2024/0744

15 Wingfield Road, Athersley South, Barnsley, S71 3PS

Erection of single storey side and rear extension

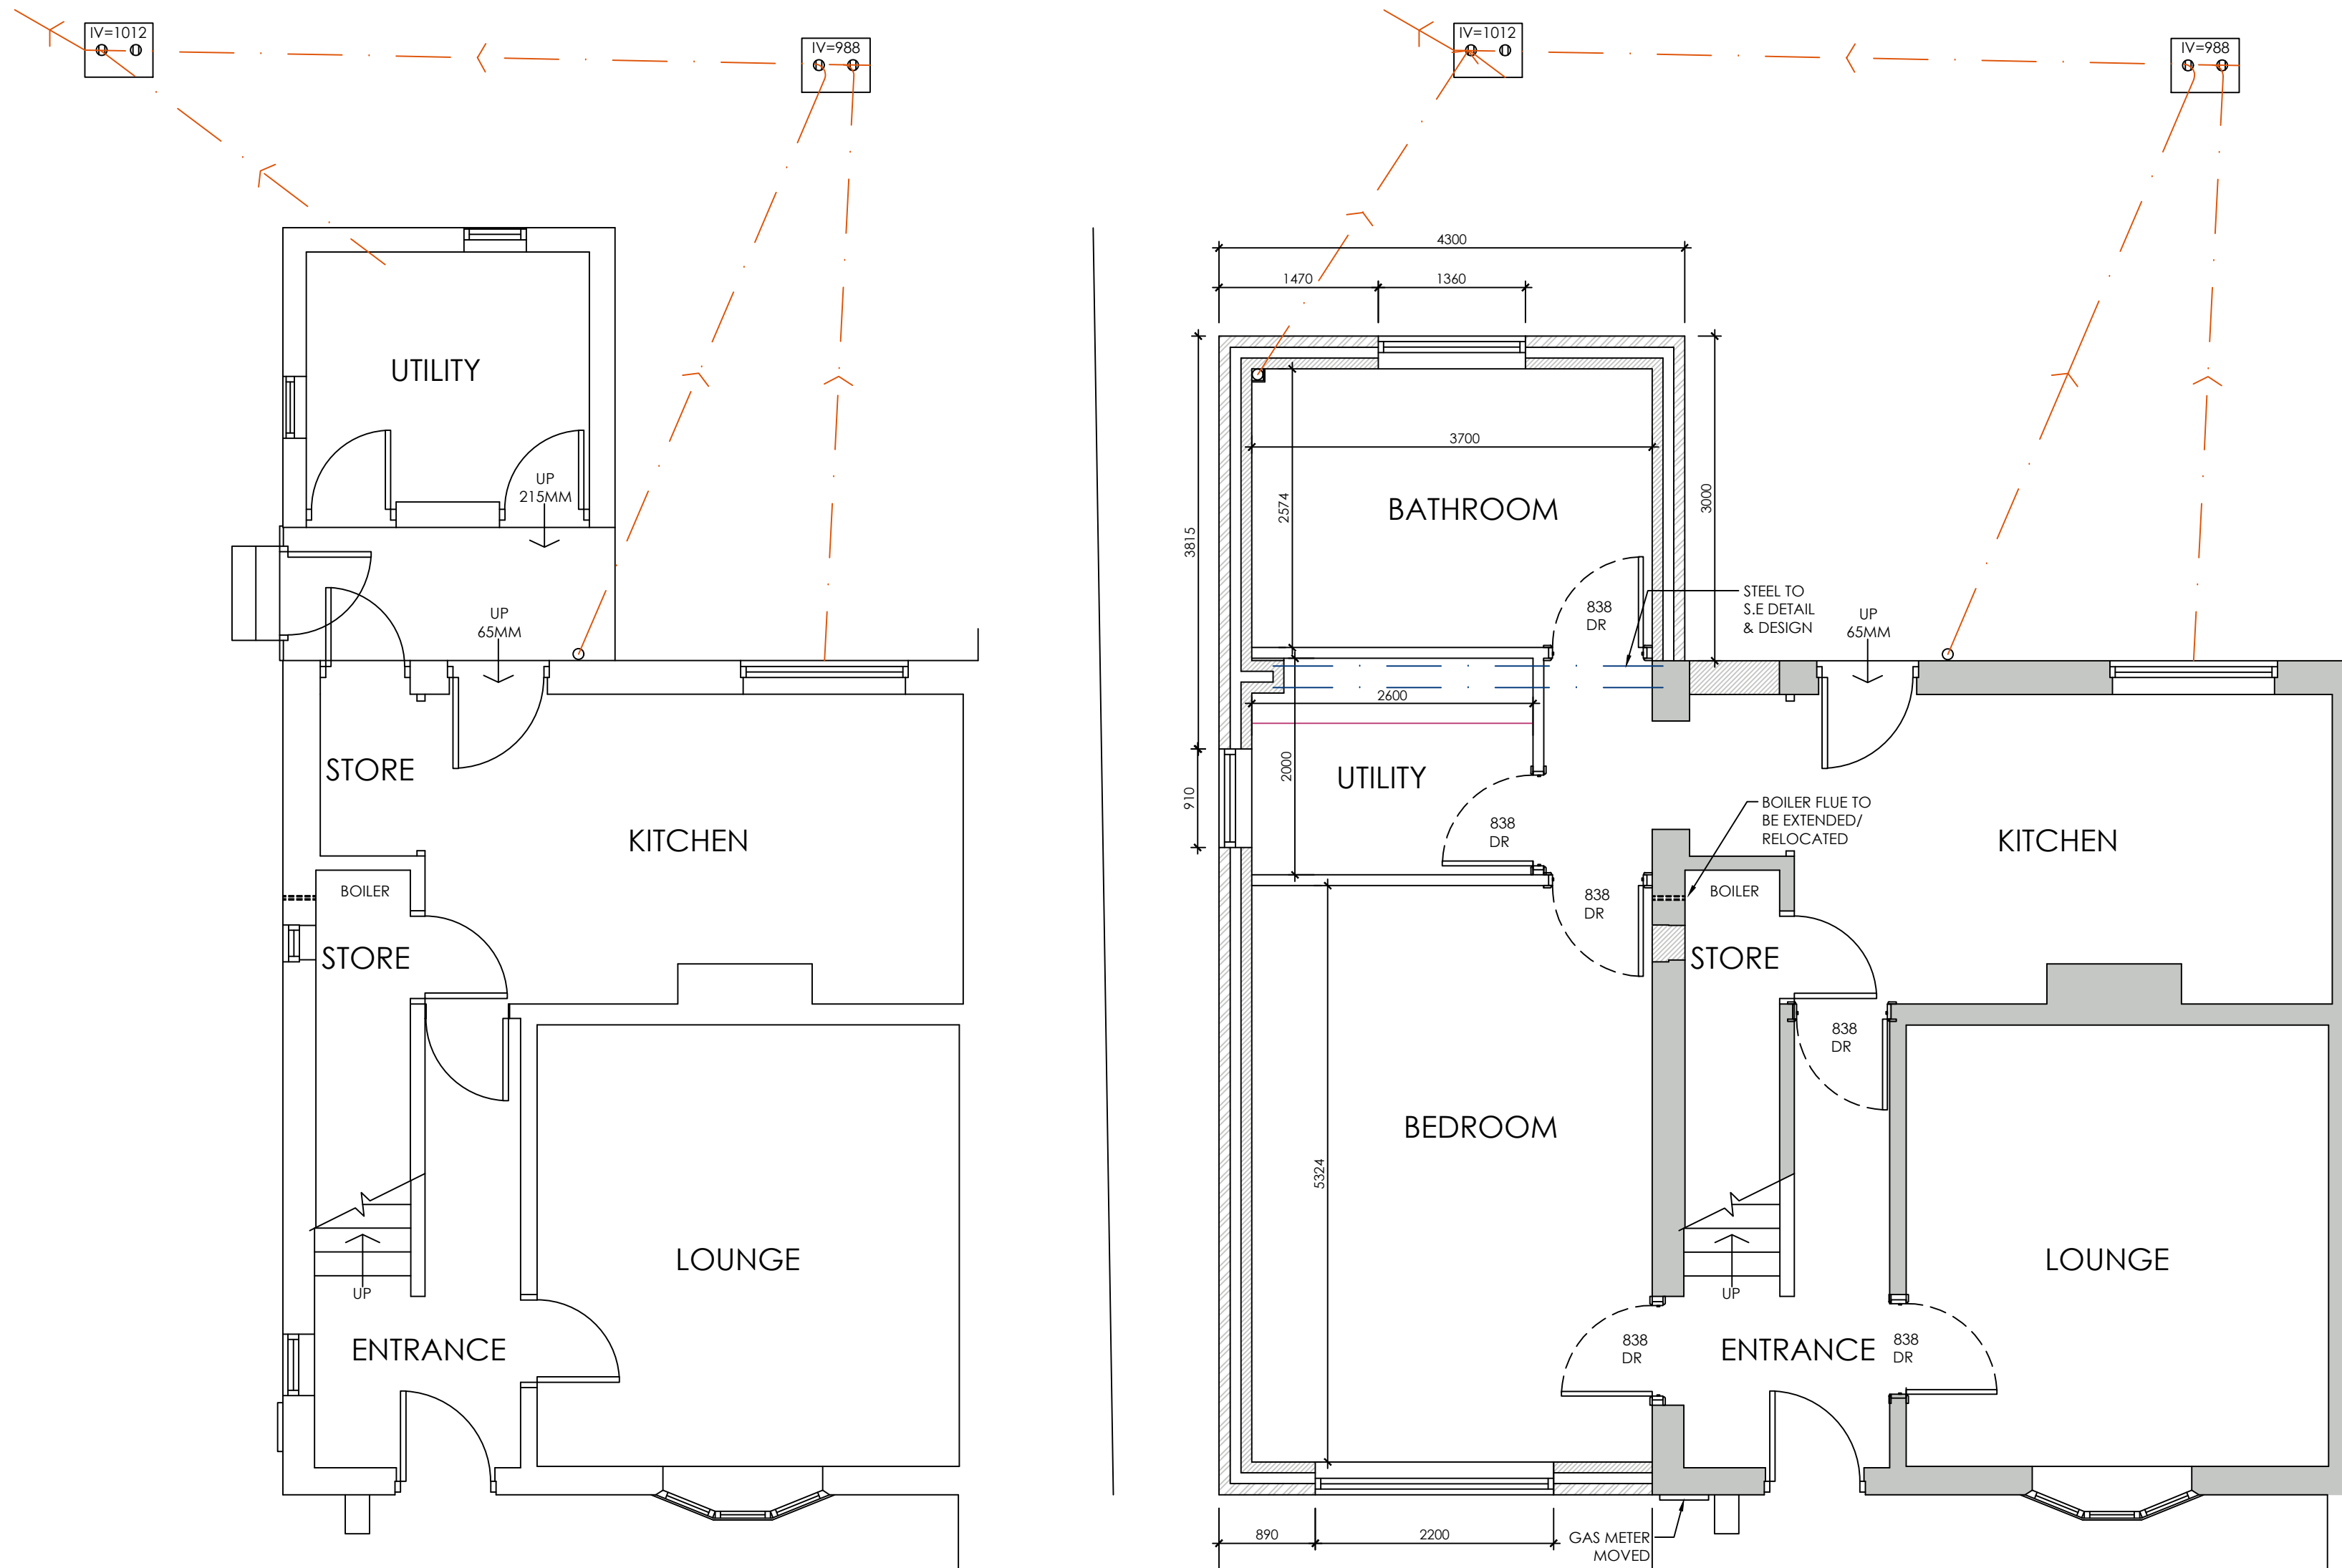
The rear window services a bathroom and will therefore be conditioned to be obscured glazing in order to protect the residential amenity of the property and neighbouring properties.

The proposal has an existing distance to the south side boundary of approximately 5 metres. Generally, on a corner plot we would therefore require a sideways projection of a maximum of 2.5 metres. However, given this proposal is to improve the living facilities of a disabled person and there is no reasonable ability to extend to the rear, we would find the proposed sideways projection acceptable.

A pitched roof form has been proposed which is preferable to flat roof especially given the plot is a corner plot. Along with matching materials this allows the proposal to be in keeping with the surrounding character of the street scene.
